Subject: **Application for Modification to Section 404 Individual Permit, Section 401 Water Quality Certification and Tar-Pamlico Riparian Buffer Certification:**  
Western Outer Loop from SR 1128 (Ruin Creek Road) to SR 1101 (Old County Home Road) near Henderson (Vance County), Division 5.  
Federal Aid Project No: STP-0509 (2), State Project No: 8.2390201,  
TIP No: U-2527, \$475.00 Debit WBS Element 34822.1.1

Reference: USACE Action ID: 199708127  
NCDENR-DWQ Project No: 031494

### Permit Drawings 6 and 23 of 41/ Site 2 (Revised August 2006)

SHEET 6 OF 41 Rev. 08/08/06

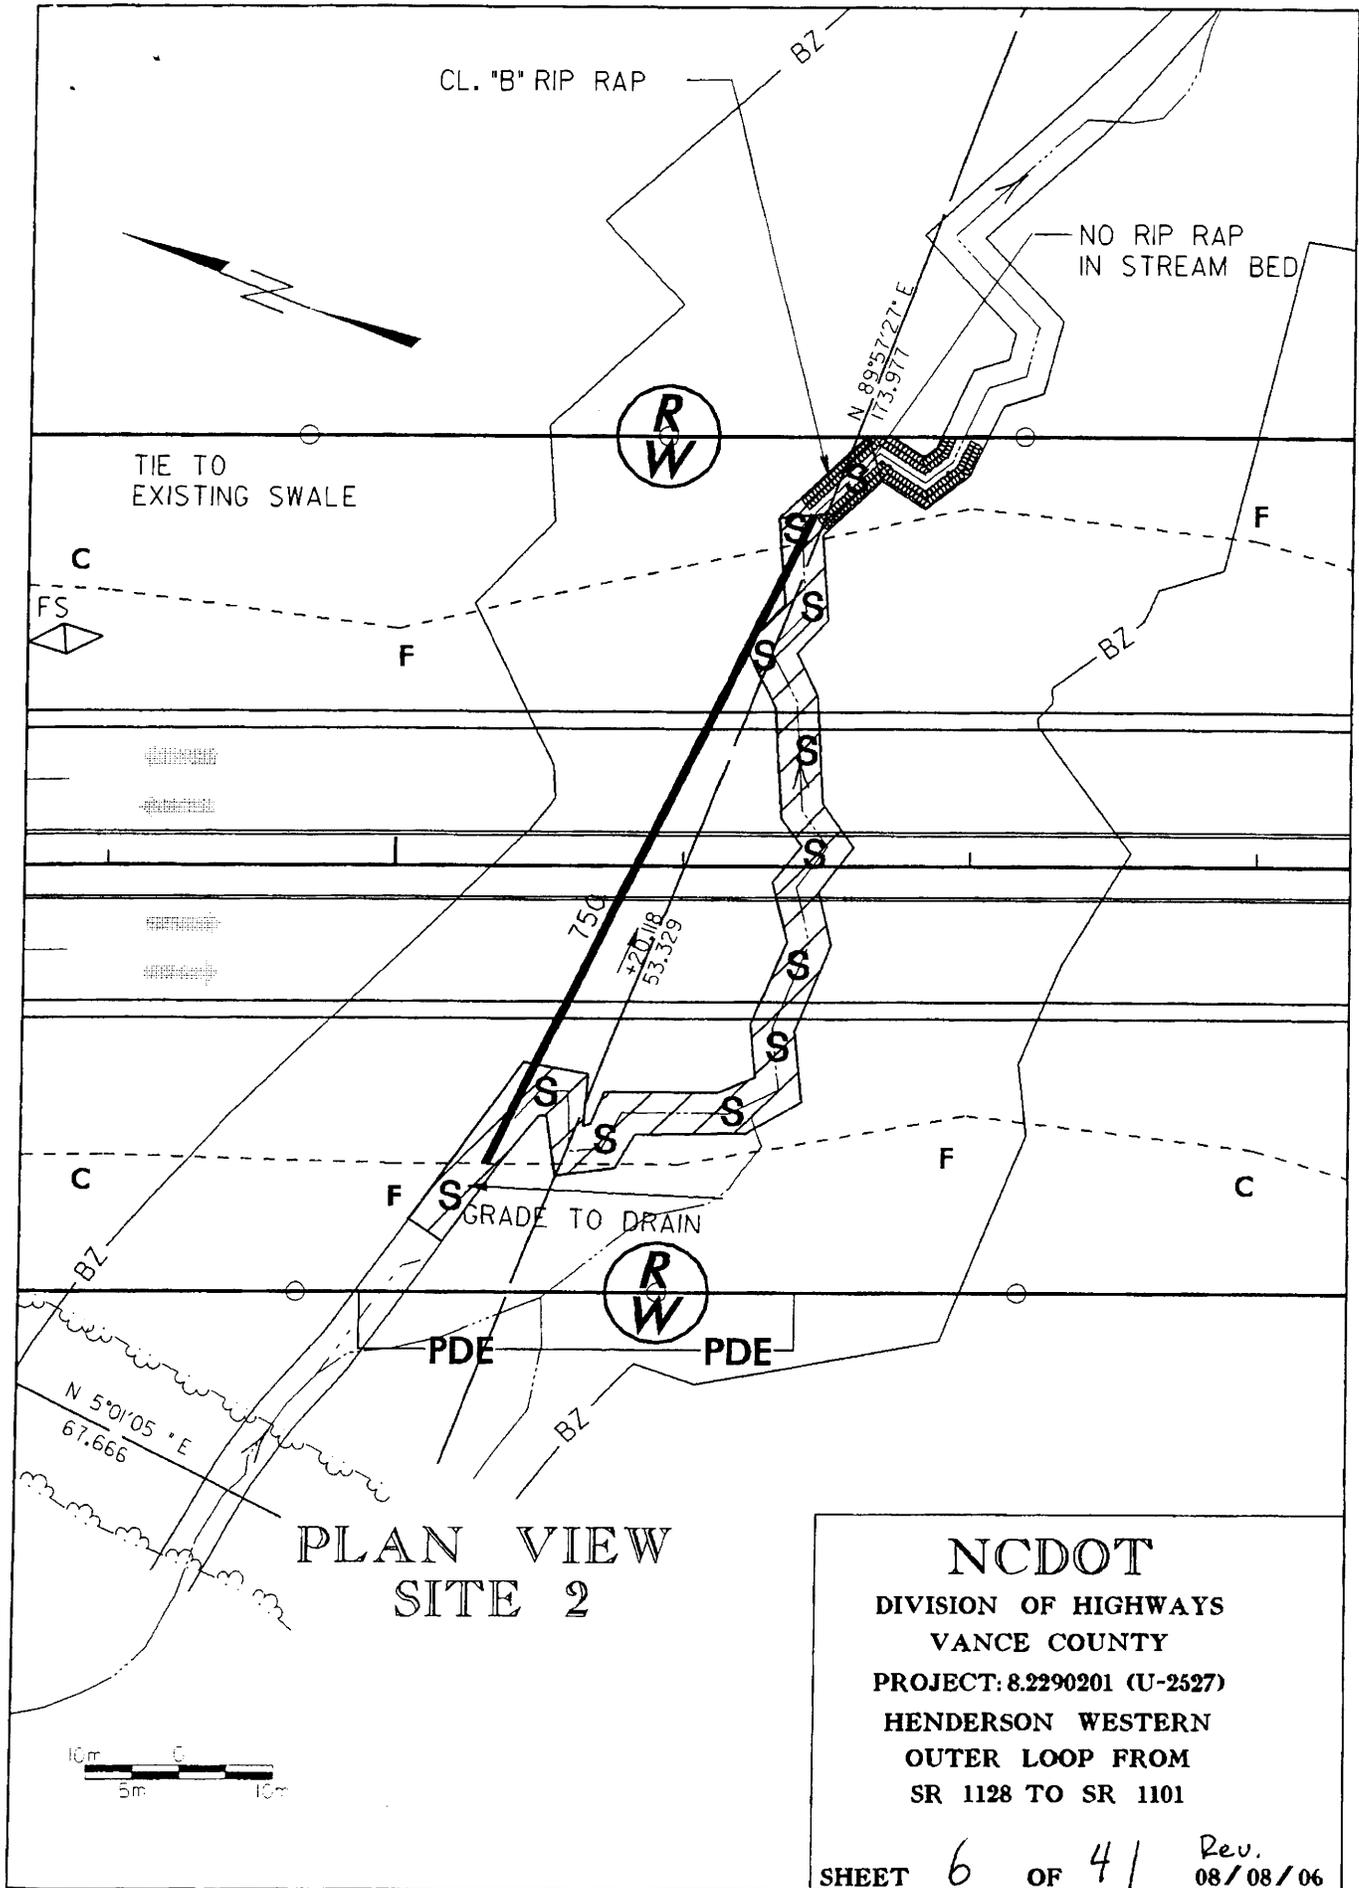
-The streambank at the outlet of the structure has become unstable within the Department right-of-way. This may be attributable to the angle of the structure at the outlet in relation to the stream.

-The Department proposes to add additional rip rap along the streambank from the outlet of the structure to the right-of-way limits, which will provide long-term stability to the system.

**\*\*This will result in the following additional impacts: 46 linear feet of surface water and 1,184 square feet of riparian buffer Zone 1.**

N. C. DEPT. OF TRANSPORTATION  
 DIVISION OF HIGHWAYS  
 VANCE COUNTY  
 PROJECT: 8.2290201 (U-2527)  
 HENDERSON WESTERN  
 OUTER LOOP FROM  
 SR 1128 TO SR 1101  
 SHEET 7 OF 41  
 REV 08//06  
 REV 06//04  
 03//16//02  
 REV. 03//06

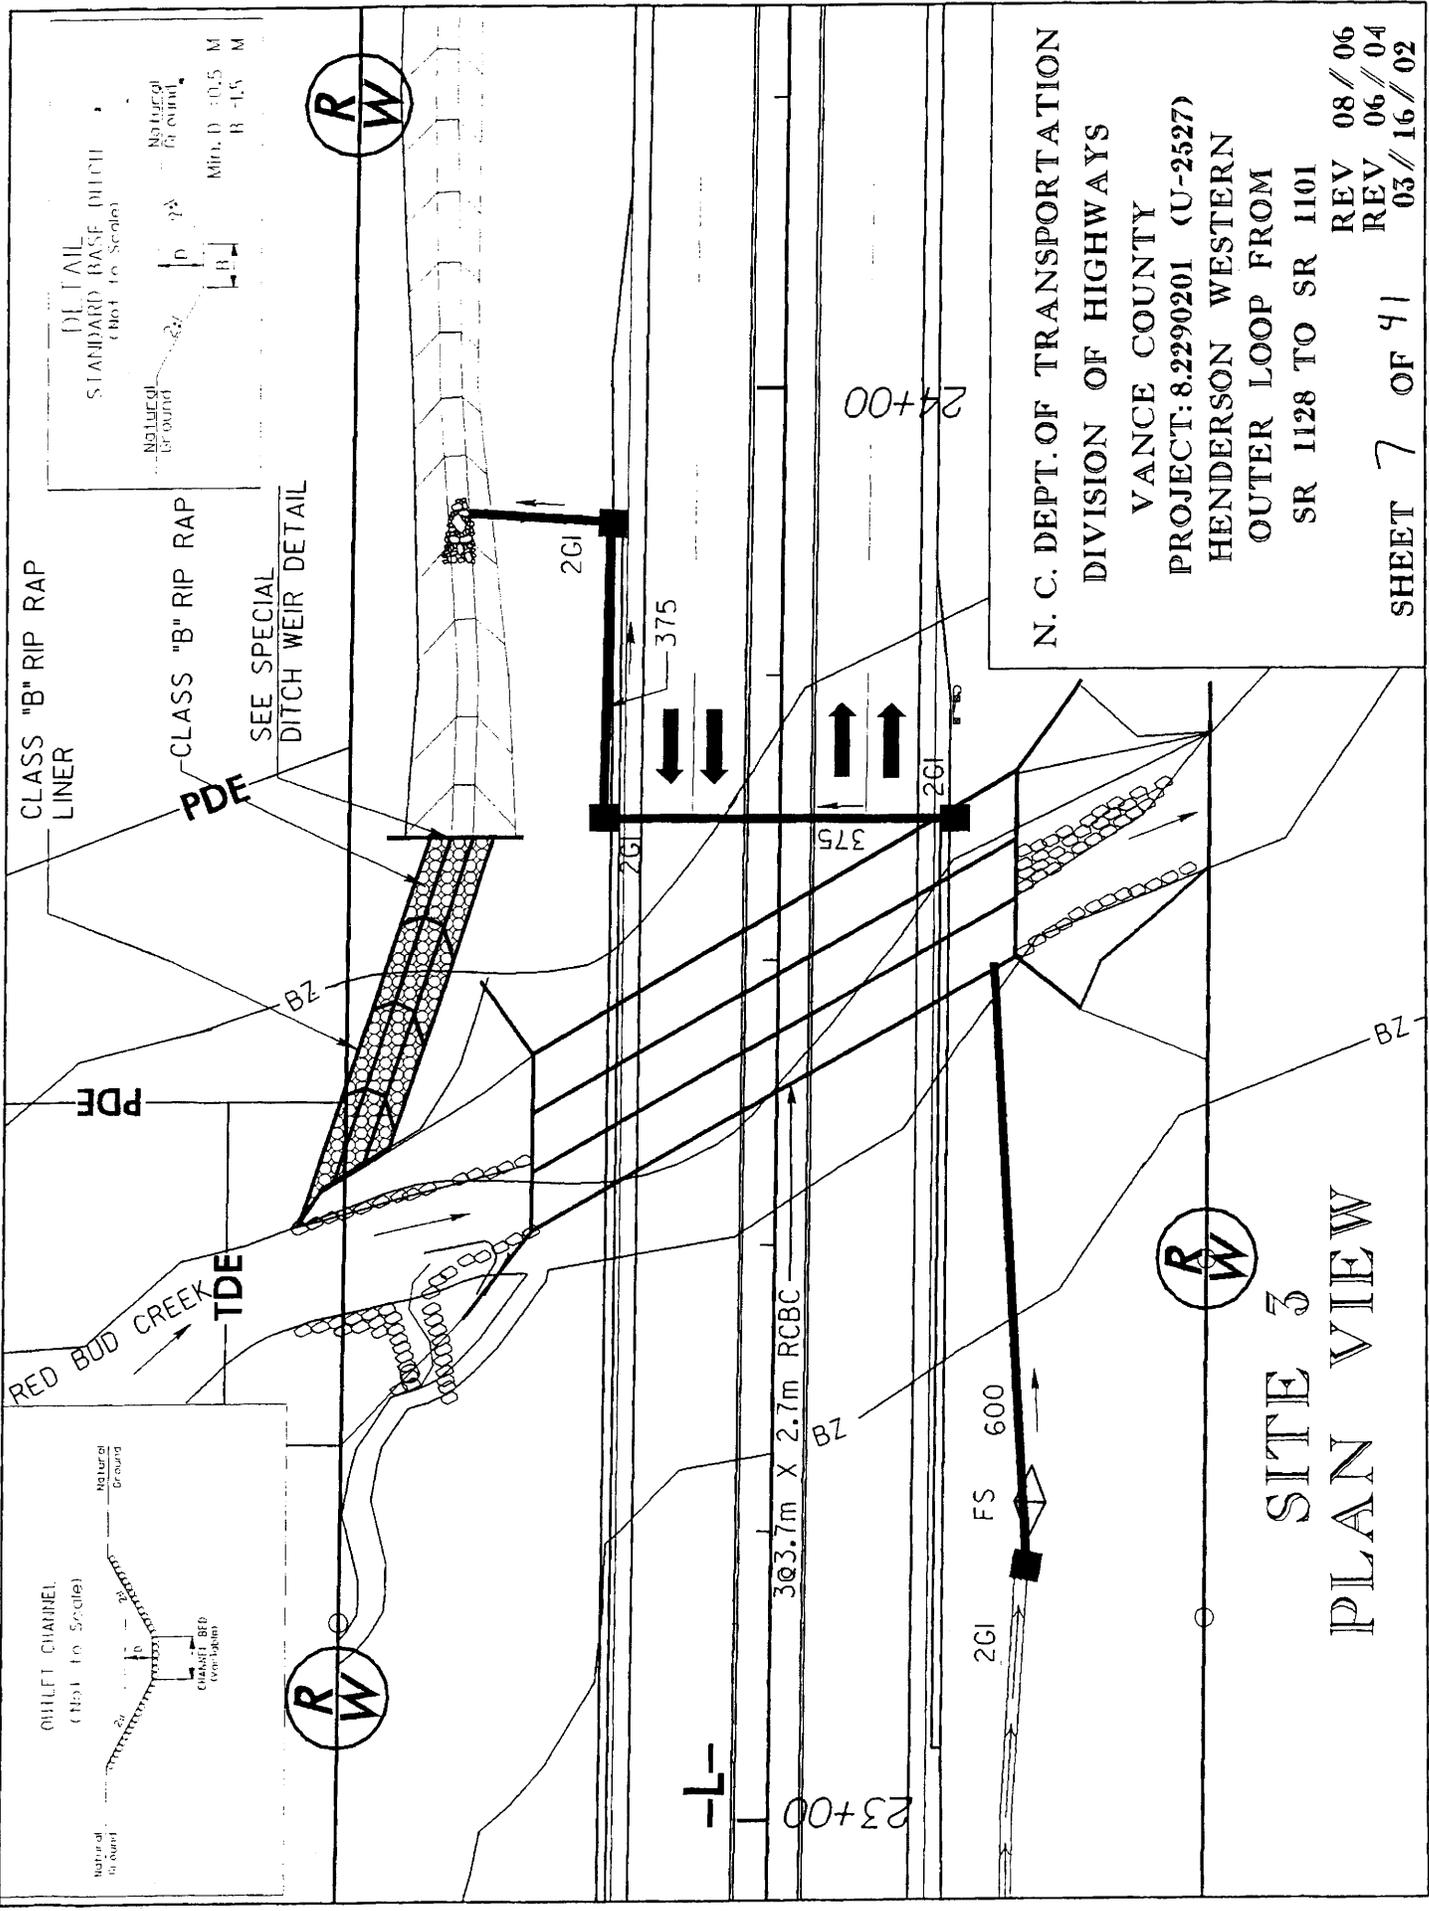
-The Department proposes to install Class B rip rap in the outlet channel below the ditch weir.

-The rip rap is necessary to provide stability to the outlet channel as it discharges to Red Bud Creek.

-The installation of the rip rap in the outlet channel does not affect the treatment of stormwater runoff at the site (note: all treatment is achieved above the ditch weir).
